Our Ref: DOC21/291828
Your Ref: SSD 10398

RE: Hanson Tweed Sand Plant Expansion, Cudgen Tweed LGA, (SSD 10398)

Enclosure: Attachment 1: Detailed BCD Comments – Hanson Tweed Sand Plant Expansion at Cudgen (SSD 10398)

TITLE
LAKE BANK PROFILE LAYOUT
 SCALE
 1:6000 AT A1
 1:12000 AT A3

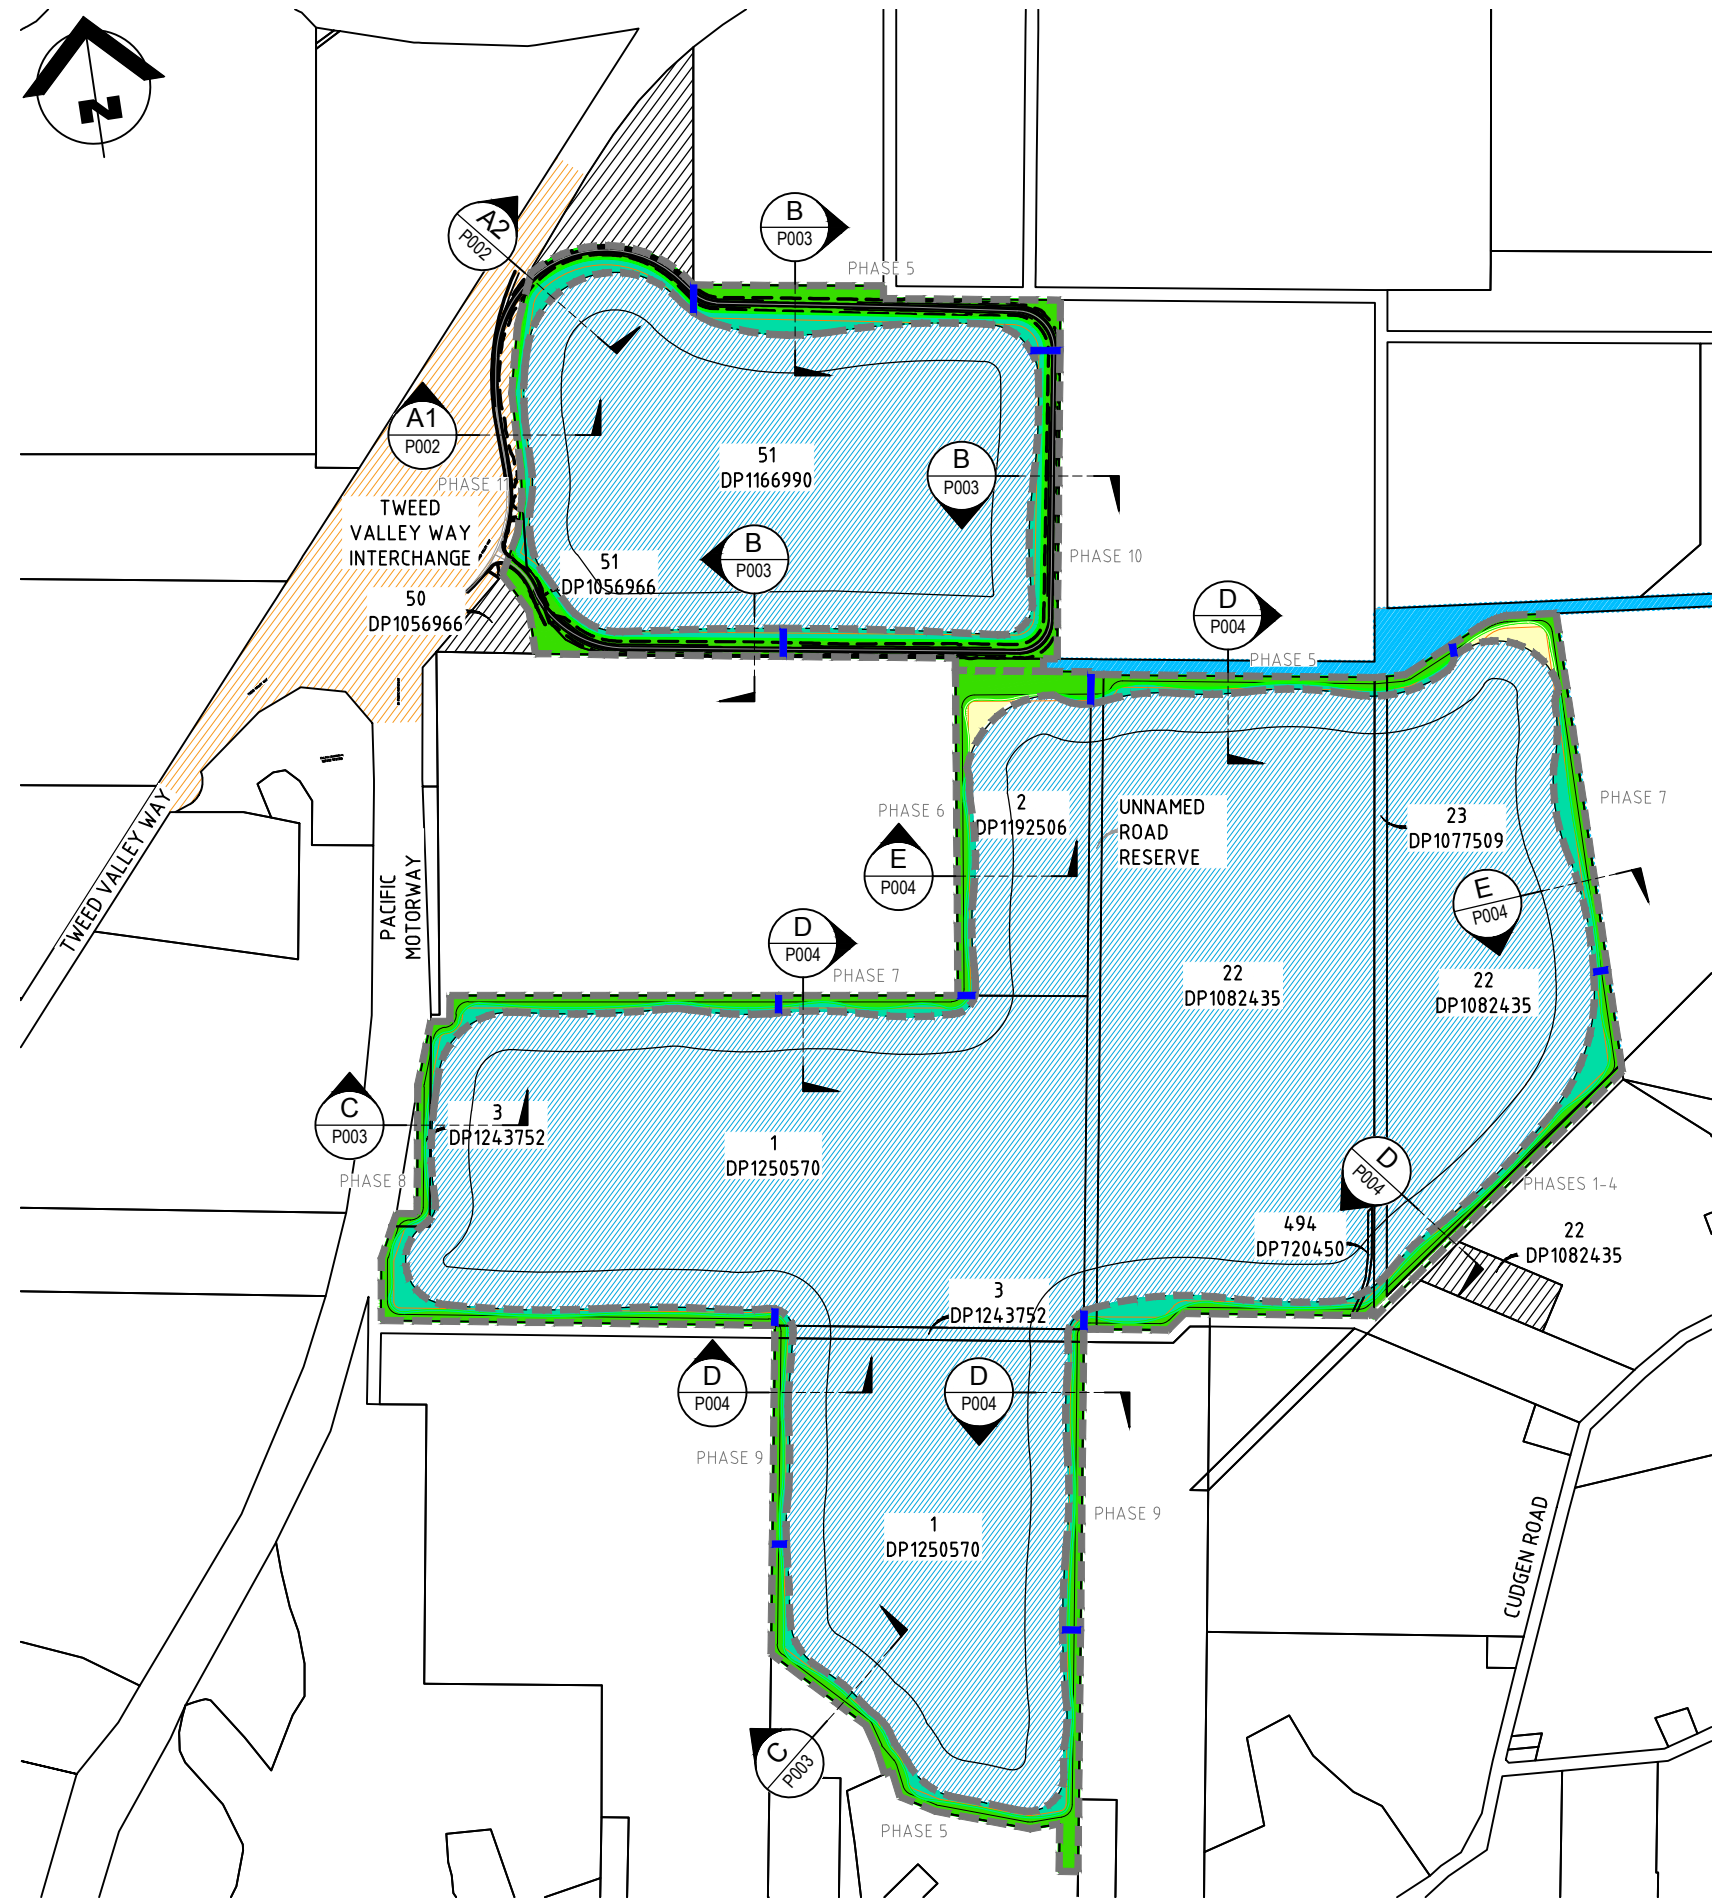
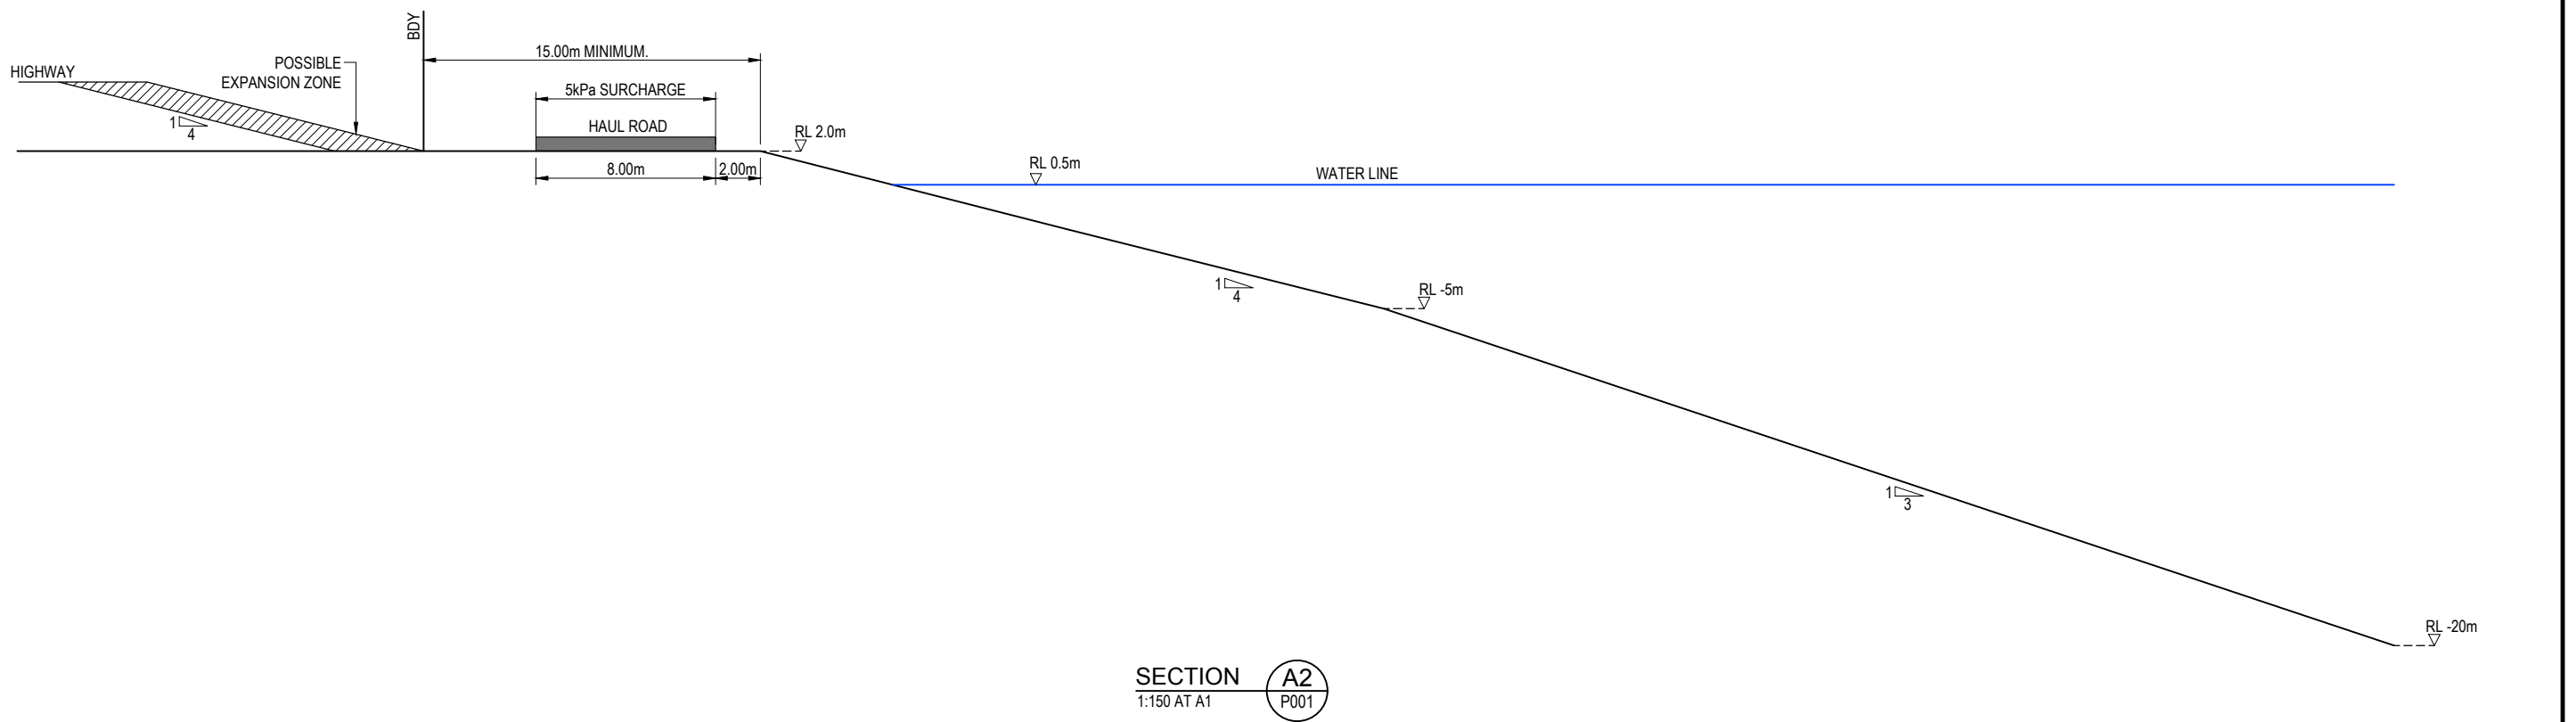
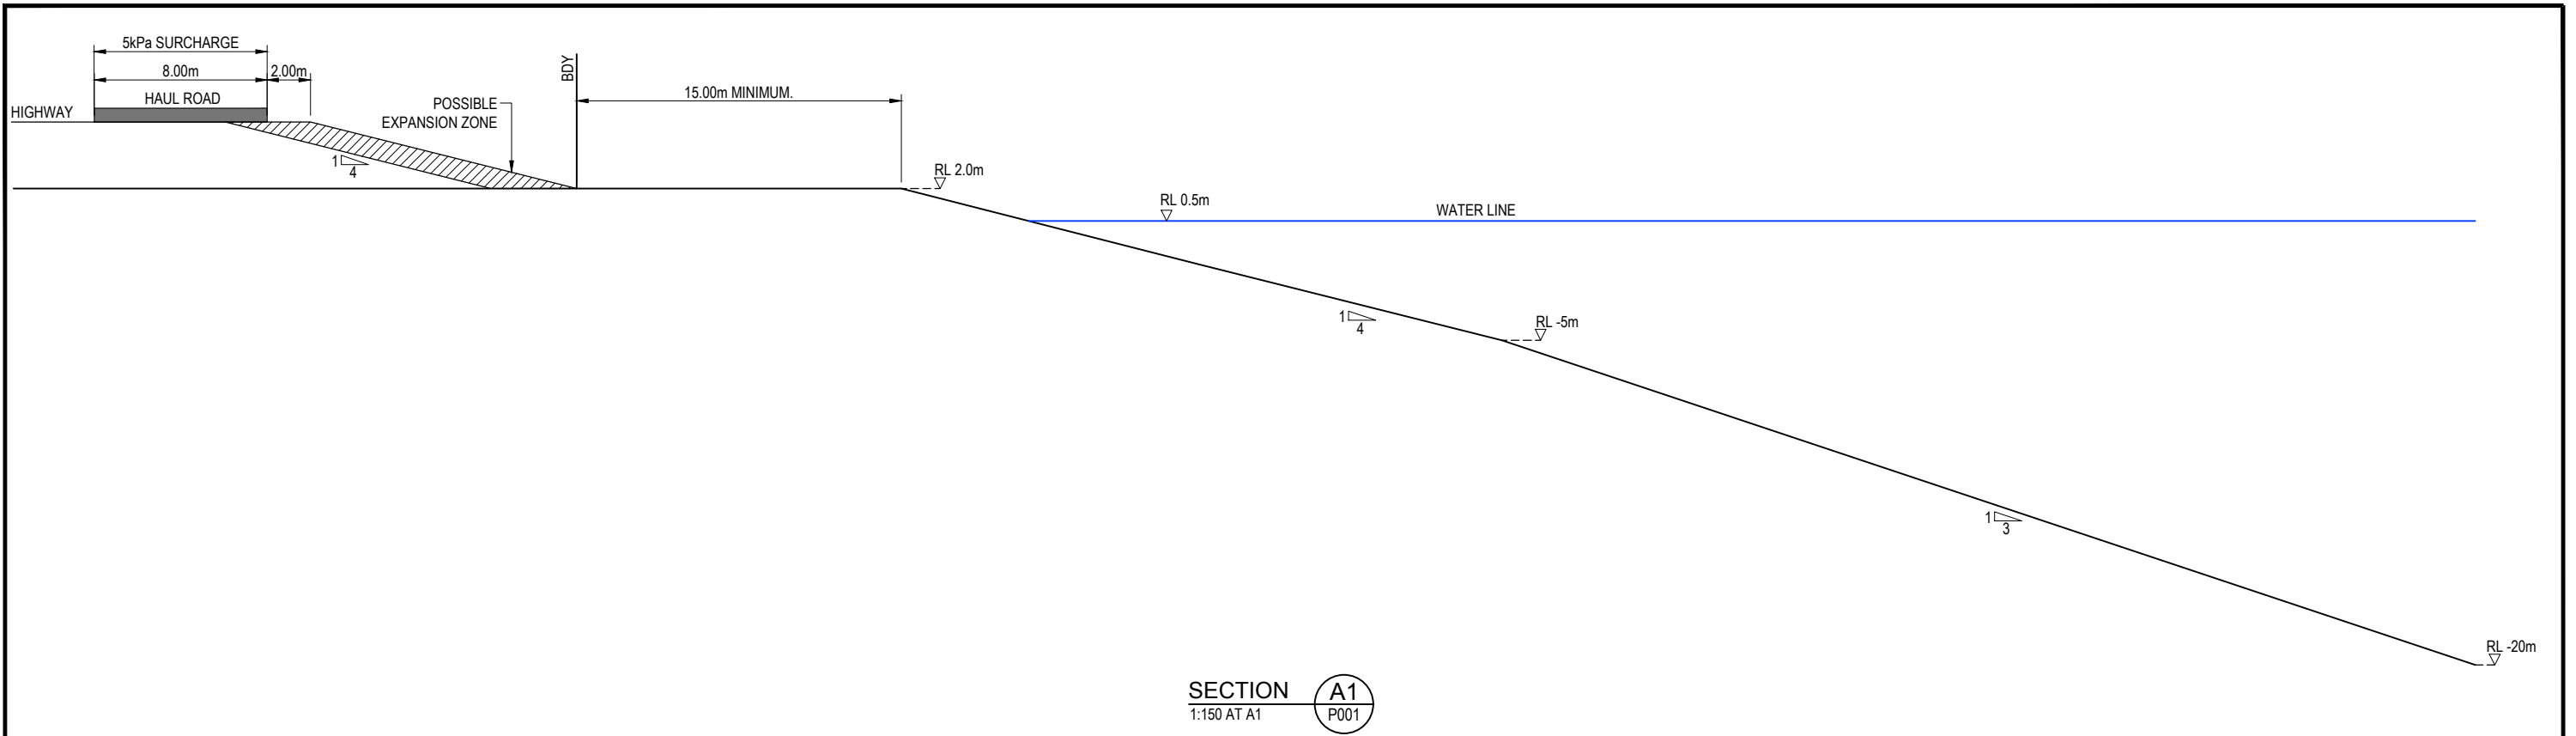
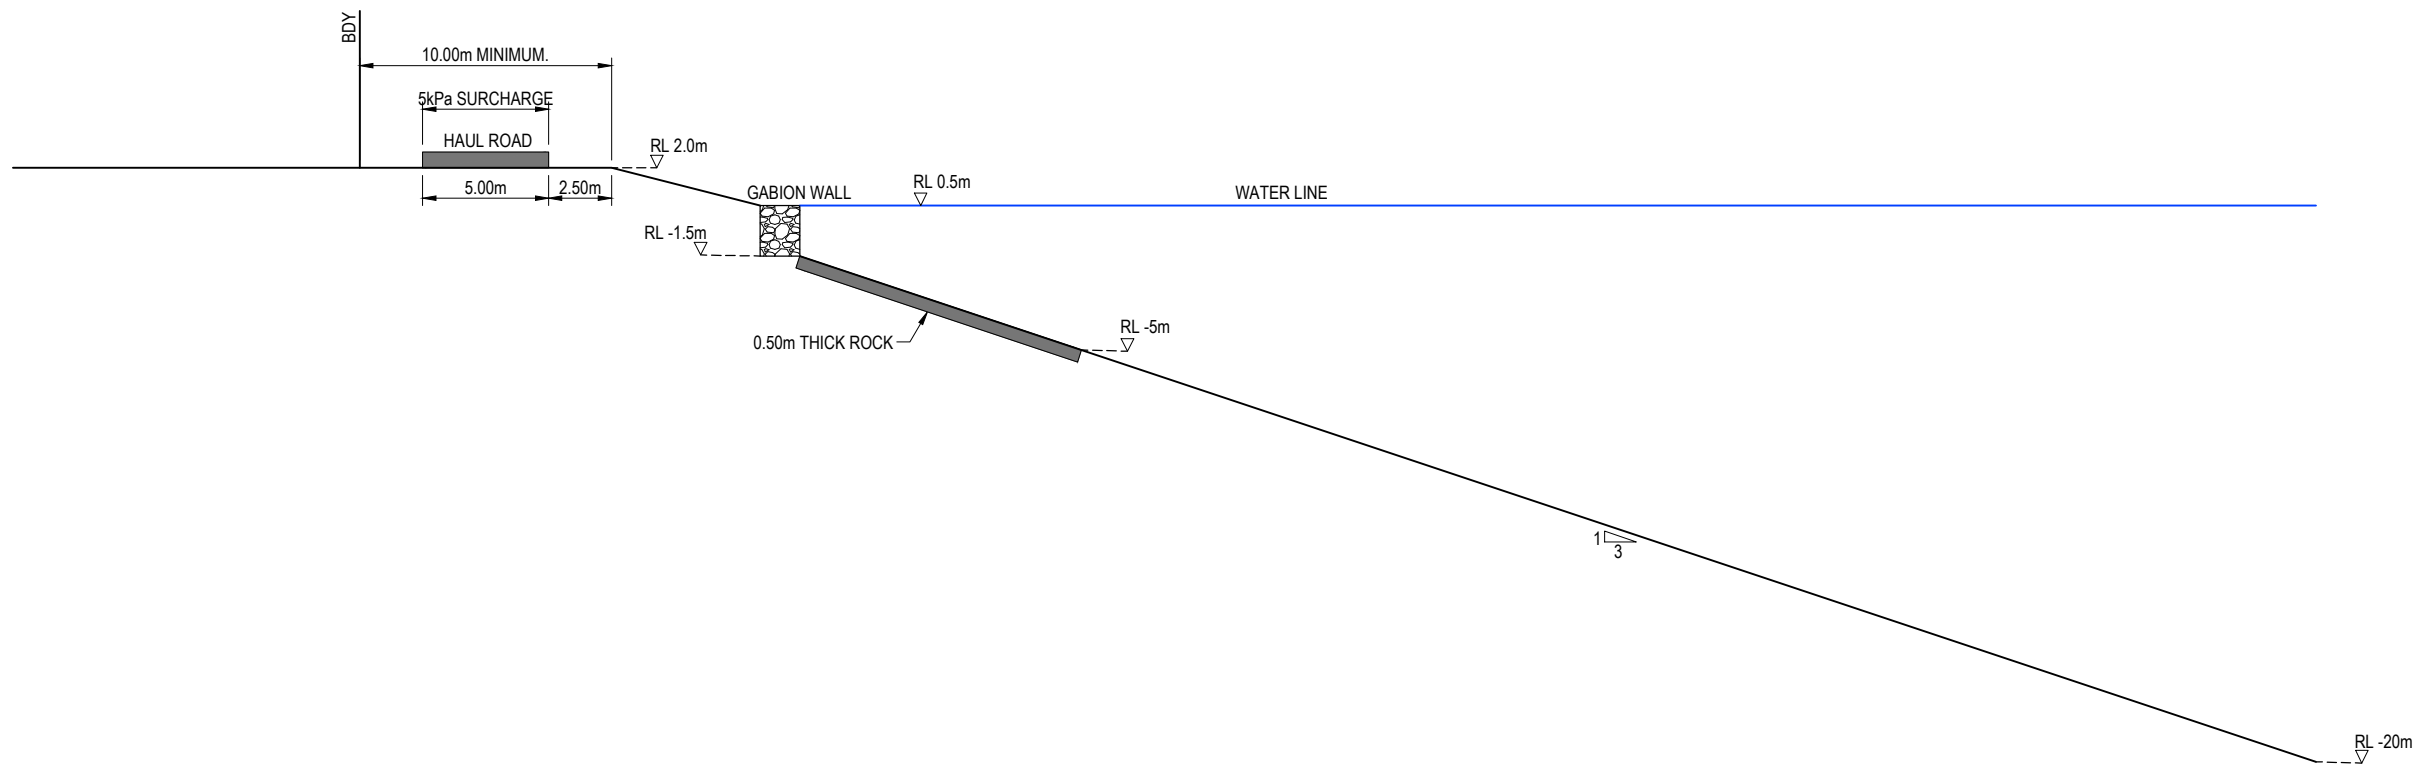
The proposed minimum 10m width of vegetation to fringe the future lakes does not appear to include any provision for vehicular access, bike/walking trails and open space as well as sufficient area to plant a riparian zone, particularly given advice in the EIS about the potential for future inundation due to sea level rise. Although there may be opportunities to create open space areas, riparian rehabilitation areas should be entirely vegetated and not be identified for open space. Such open space recreational areas should be additional to that required for rehabilitation.

The BAM 2020 prescribes riparian buffer distances of 50m for estuarine areas, 50m for important wetland and 20m for other wetlands. While none of these directly apply in this instance we recommend as a minimum that the final landform include 20m – 50m wide fully vegetated riparian areas. It should also include a minimum 10m wide wetland revegetated area with appropriate slope to enable effective restoration to occur and for areas to be maintained in the future.

7. If the consent authority decides to approve this development, the riparian rehabilitation should provide as a minimum, 20m – 50m wide fully vegetated riparian areas. It should also include a minimum 10m wide wetland revegetated area with appropriate slope to enable effective restoration to occur and for areas to be maintained in the future.
